**RE: Wilshire Place Subdivision
Conceptual Grading and Drainage Plan
Engineer's Stamp Date: 02/15/18
Hydrology File: C18D103**

Based upon the information provided in your submittal received 05/11/2018, the Conceptual Grading and Drainage Plan **is not** approved for action by the DRB for Preliminary Plat and Site Plan for Building Permit. The following comments need to be addressed for approval of the above referenced project:

Sheet Title
**DRAINAGE AND
CONCEPTUAL GRADING PLAN**
Date
AUGUST 10, 2018
Project No.

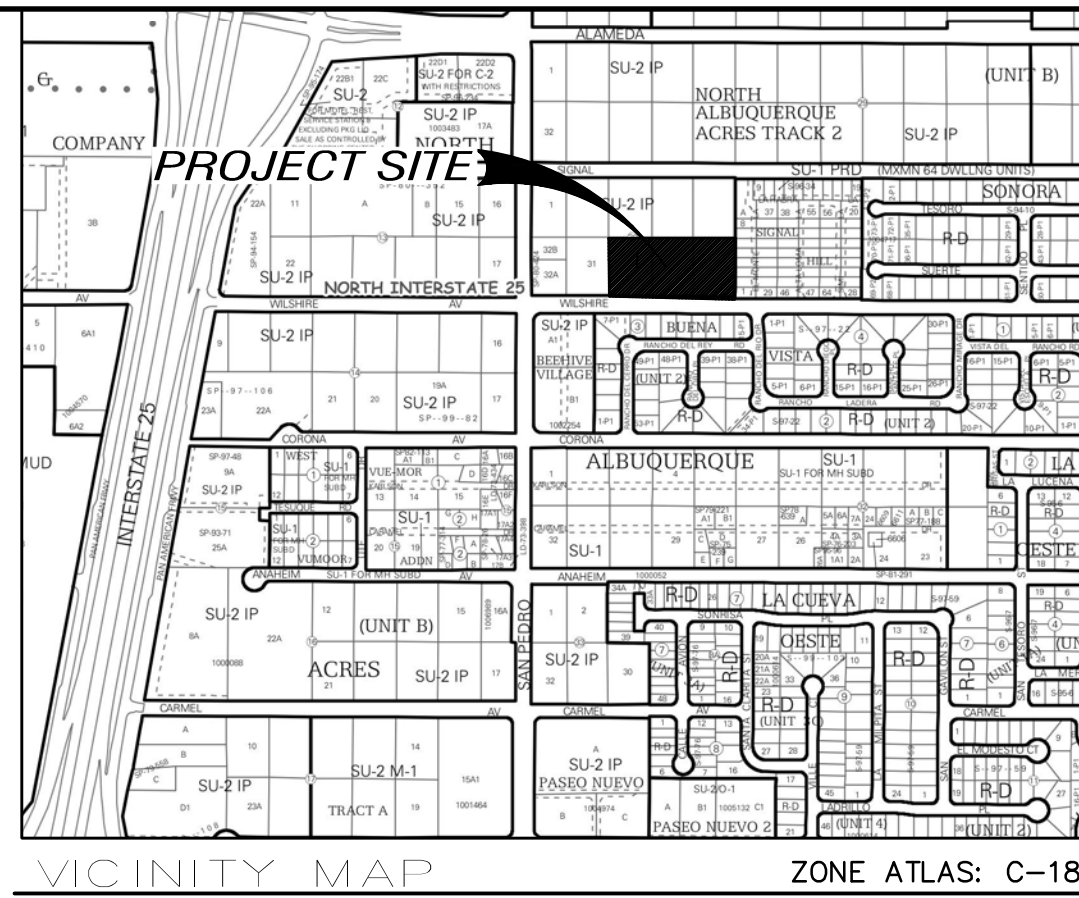
1. Please provide a vicinity map showing the location of the site.
2. Please provide the benchmark information for the survey contour information provided.
3. Please add a note that this site is within the North Albuquerque Acres Master Drainage Plan. This site has an allowable discharge of 3.47 cfs/ac. Therefore this 2.65 ac site can discharge 9.20 cfs.
